D1 Submission: Design Concerns.

D1 Submission: More Concerns.

**Illustrative Masterplan
Figure 5.5A: Cable Corridor Option A**

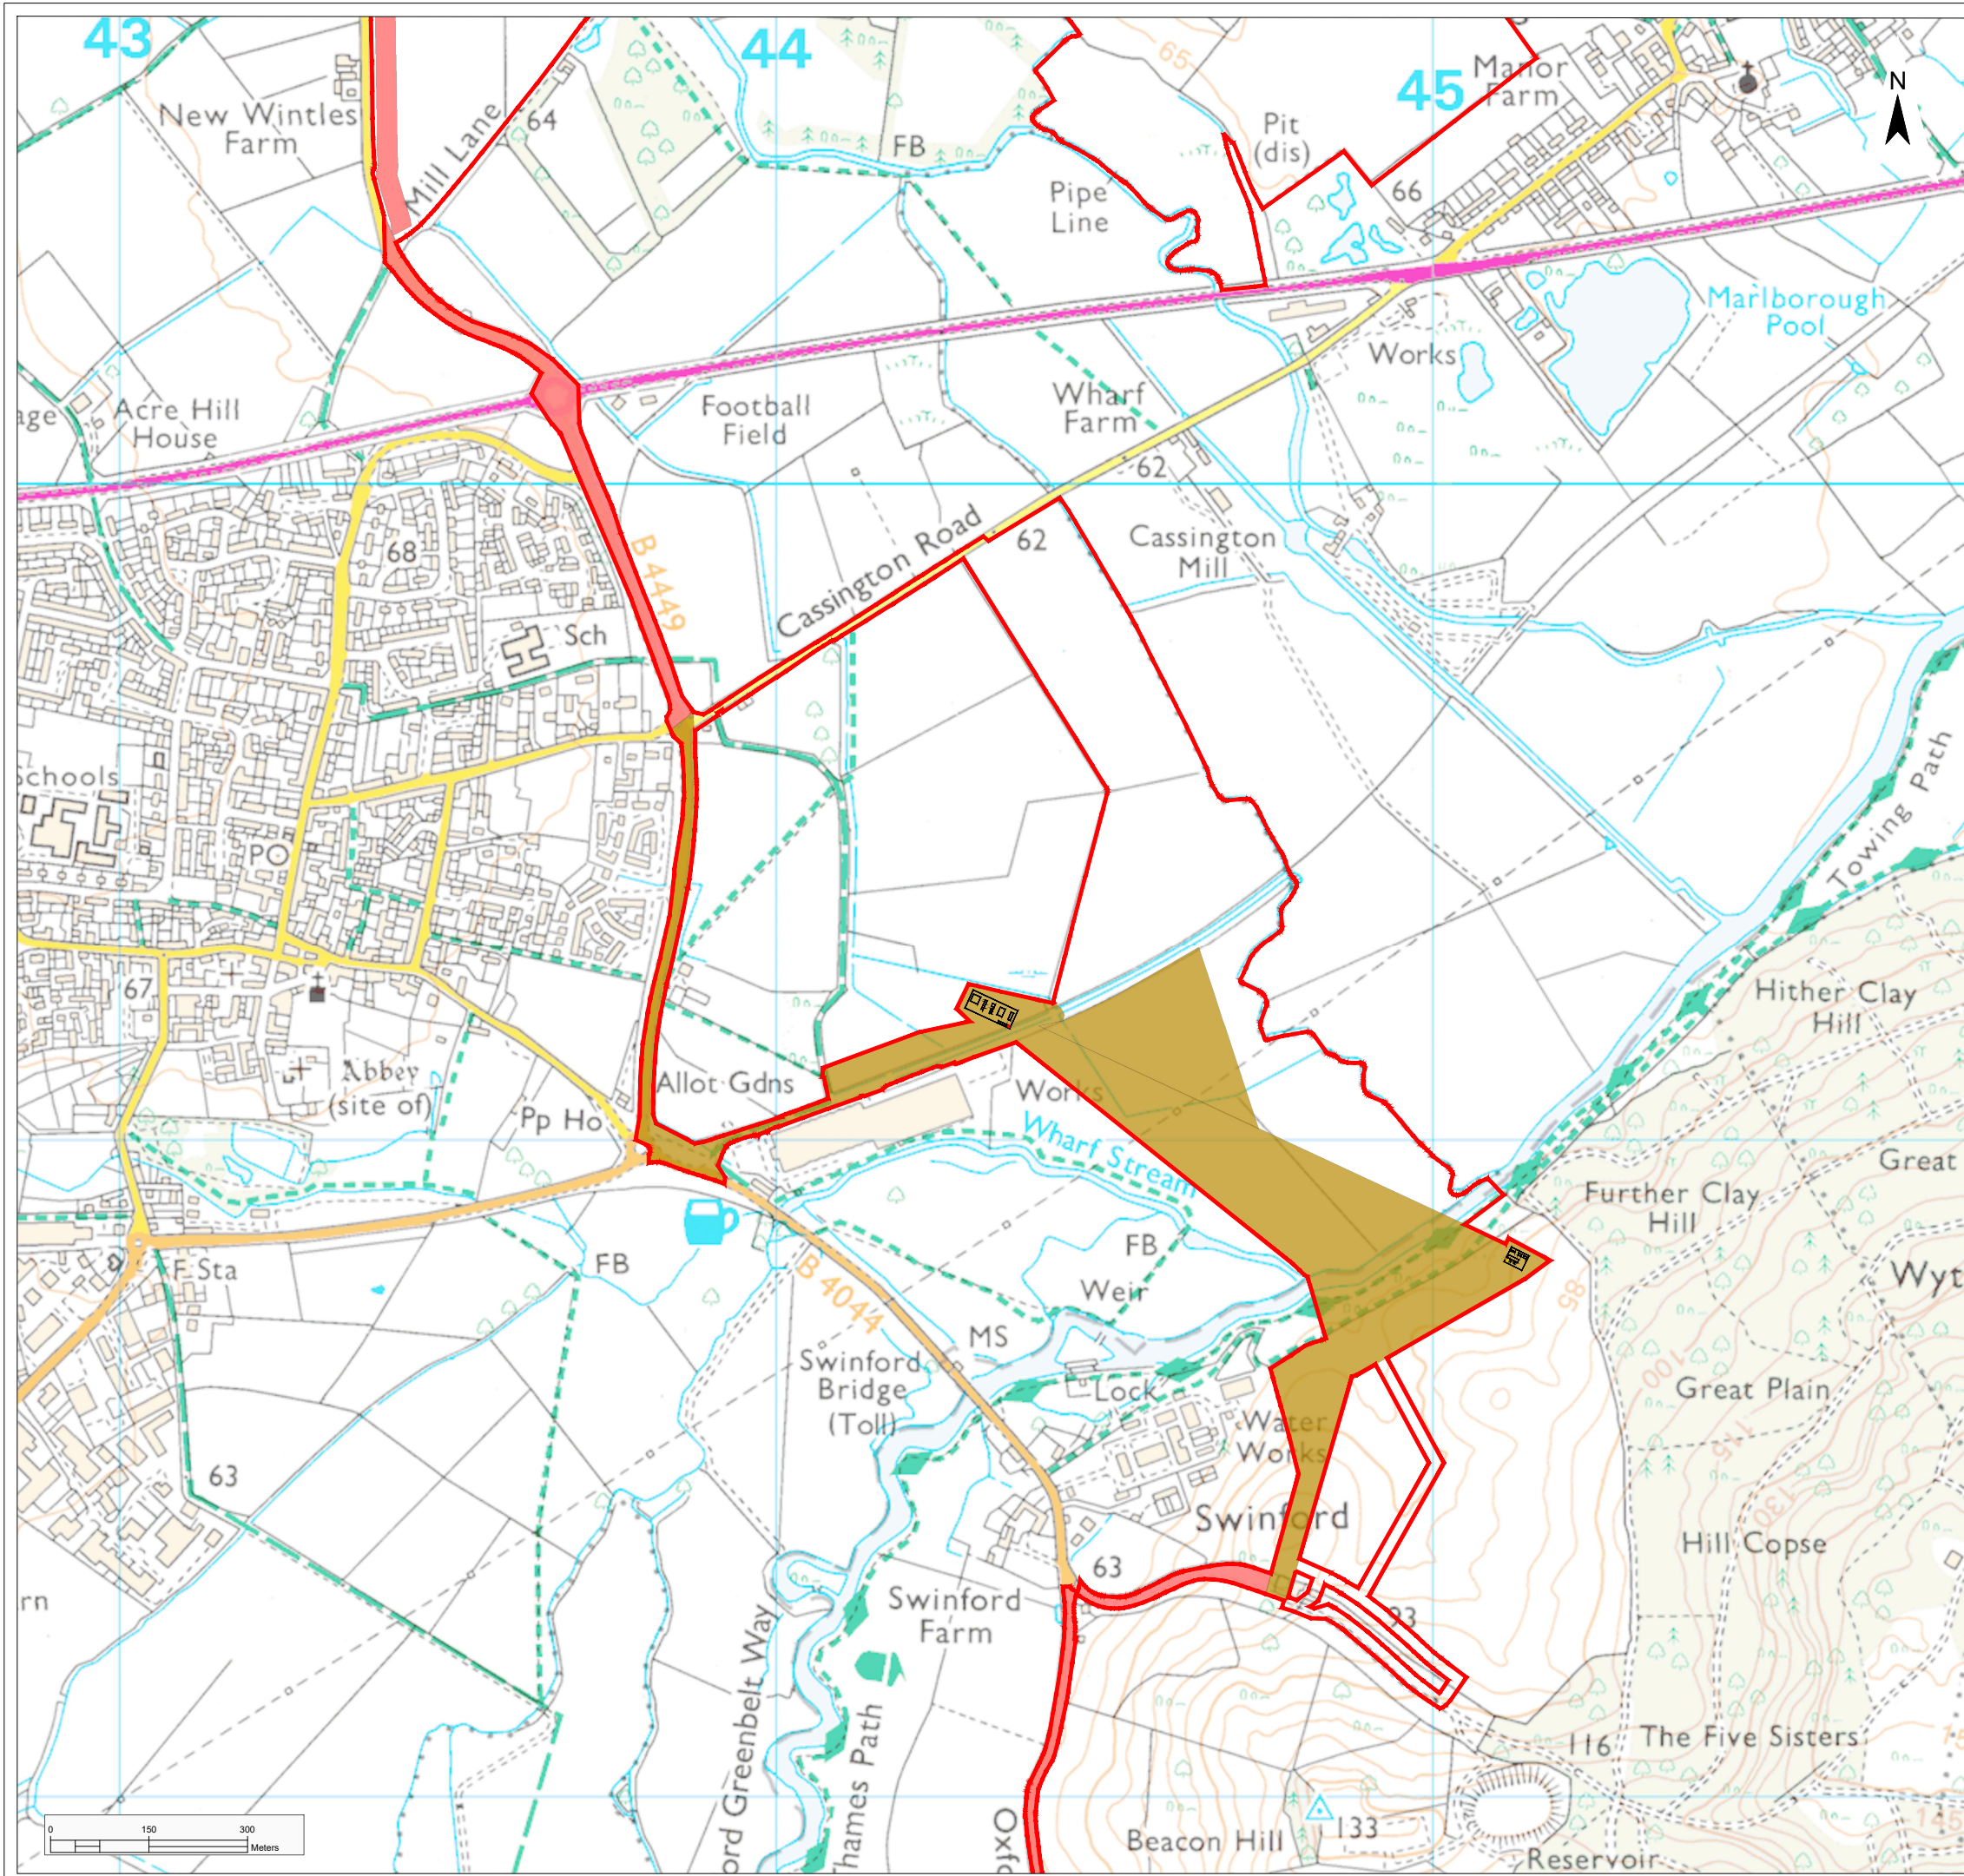
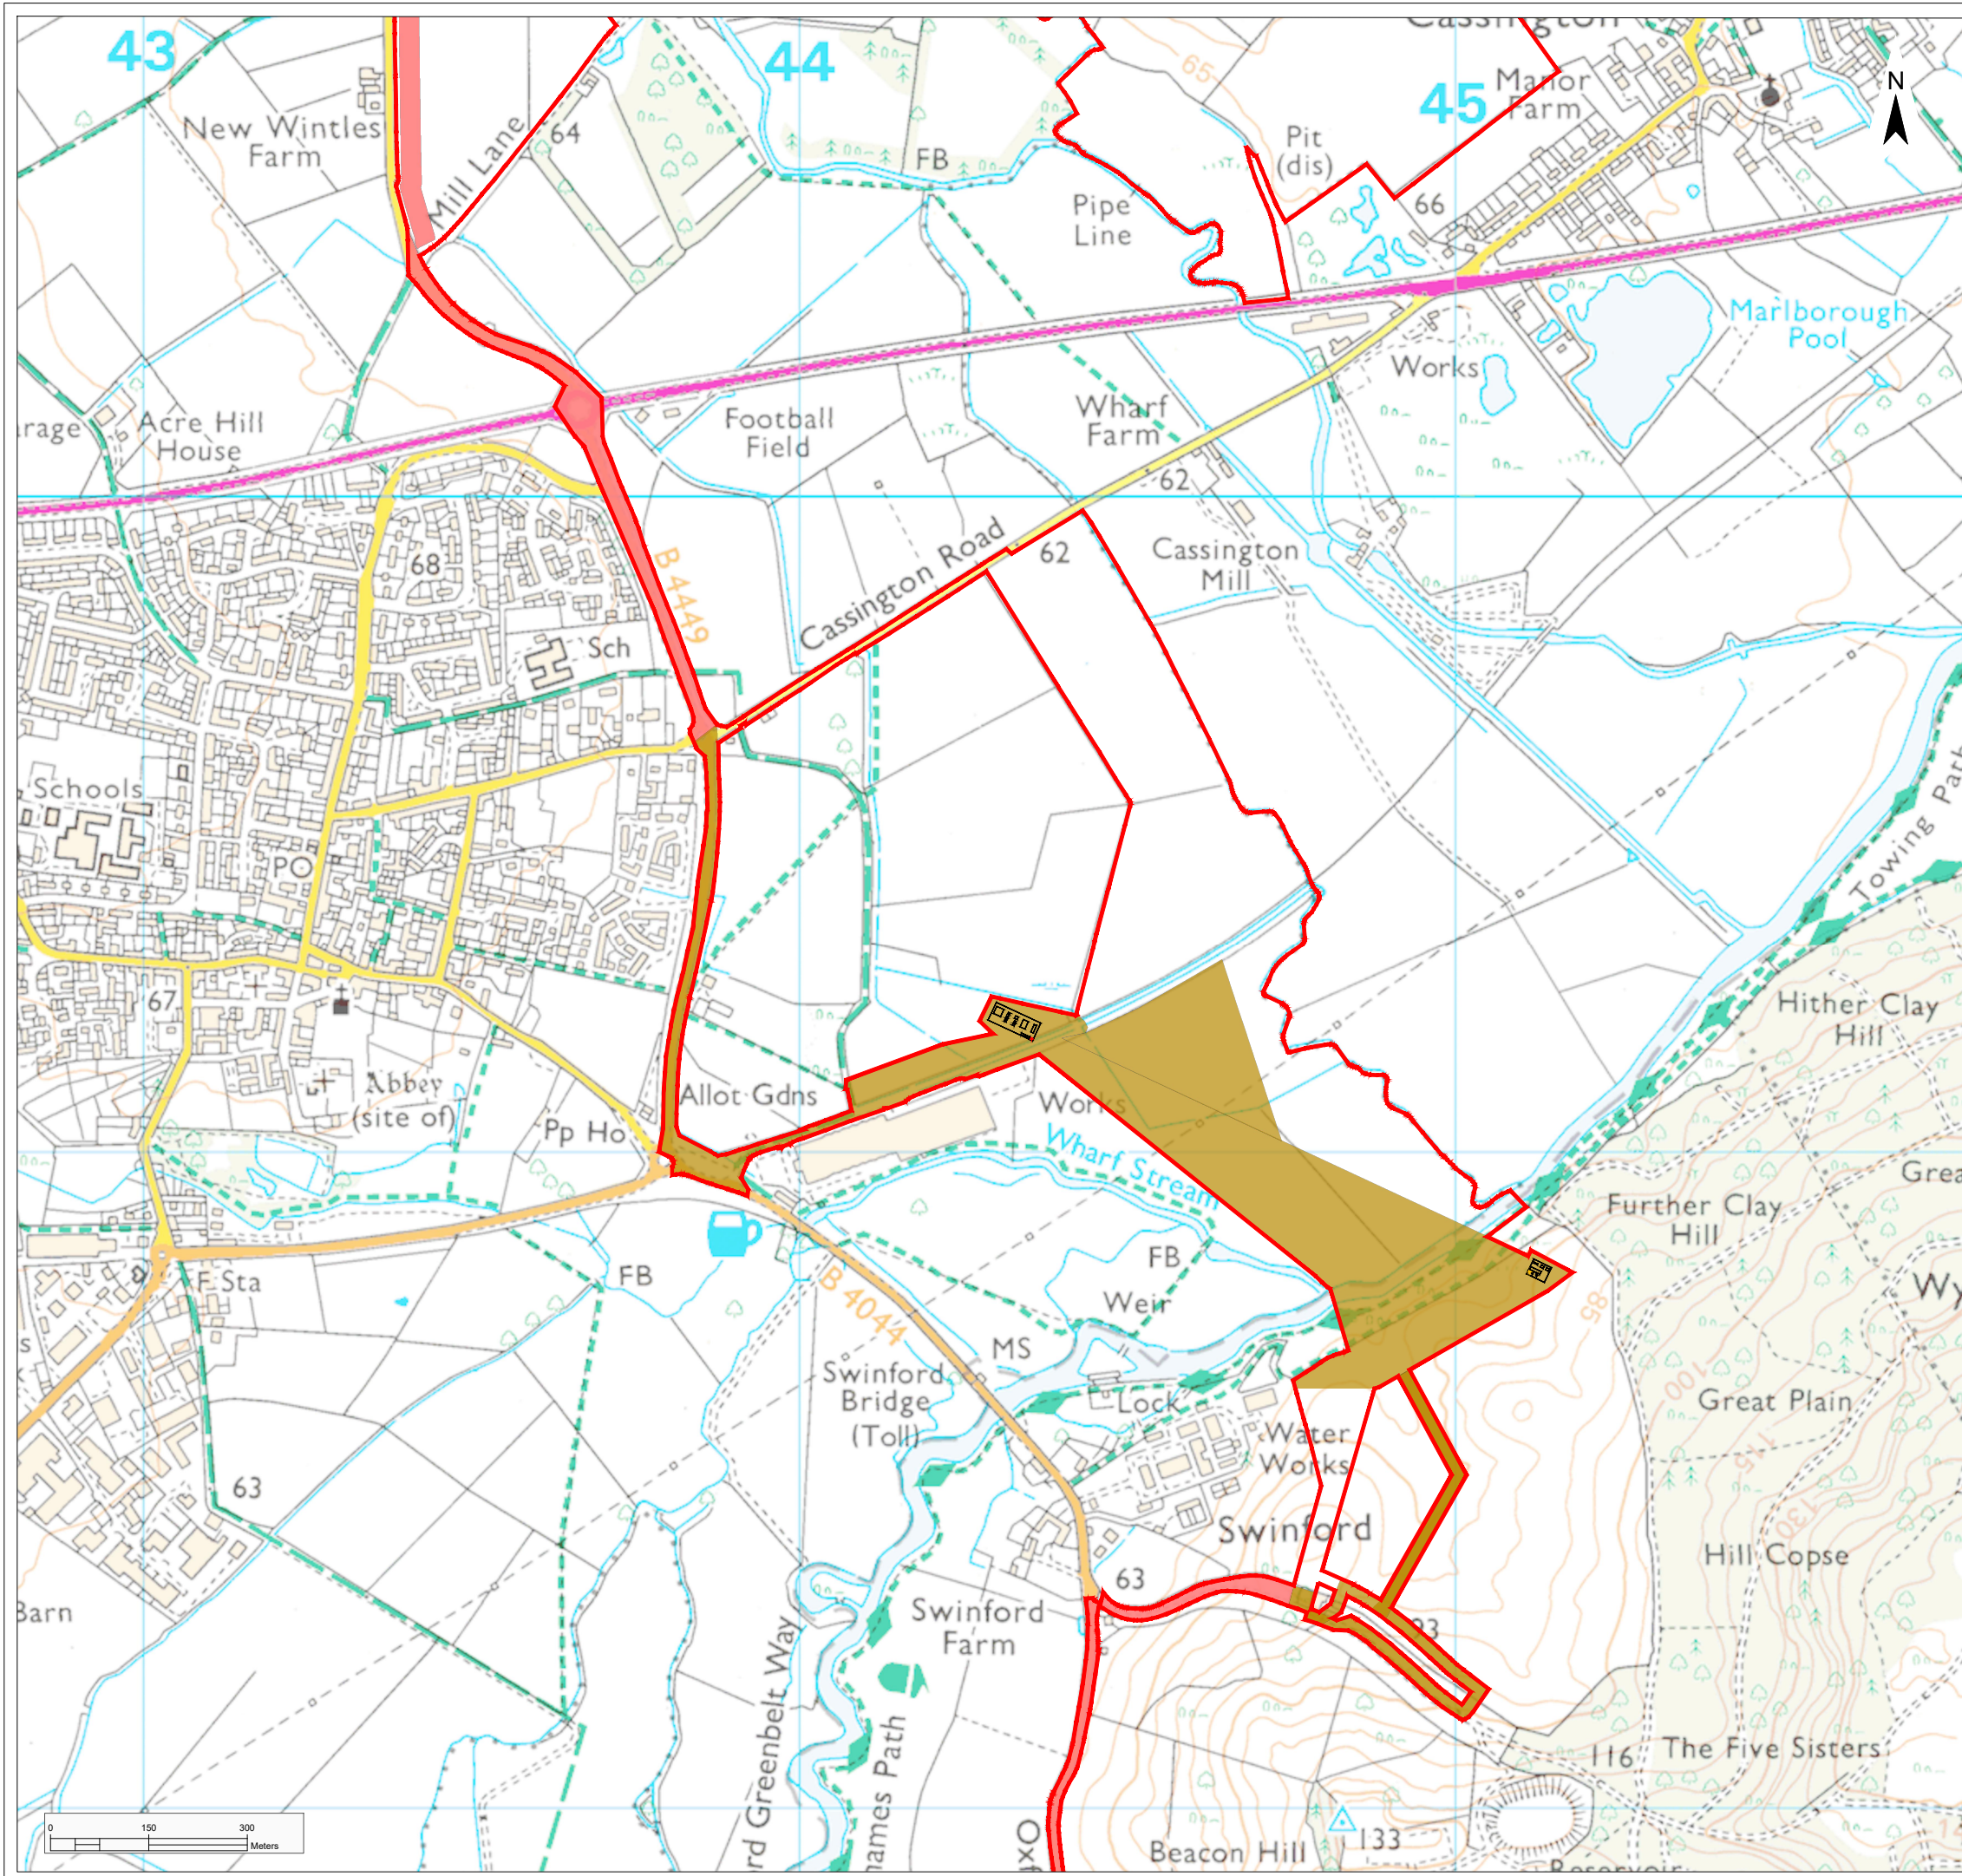
1) There are many ultra-short tables (e.g. **1** and **2** in the diagram). The Scoping Report gave a minimum table length of 14m. Project Description reduced this to 3m. Table **1** looks like a single panel width: 1m.

2) The Masterplan also shows the network of roads (**R**) than run around the perimeters and across the fields. These are coloured grey here but are described as 'grass with occasional matting' or 'natural ground surface' [[OOMP](#), p6]. Are these sufficient to support the weight of emergency fire tenders year-round? Has Oxfordshire Fire and Rescue been consulted? The roads look a bit narrow for the job (2.5m), and the turn radii are certainly far too tight to be negotiated by a fire tender. Should some panels be removed to relax the radii?

3) The north-south table gap is specified in Project Description as between 1.5m and 3.0m; the gaps measured on the Masterplan are 1.5m (panel:gap ratio 3:1).

4) Similarly, Table 6.3 of Project Description specifies a minimum distance of 7m between the fencing and the solar tables, whereas the Illustrative Masterplan shows PV panels consistently packed in with a fence separation of less than 5m.
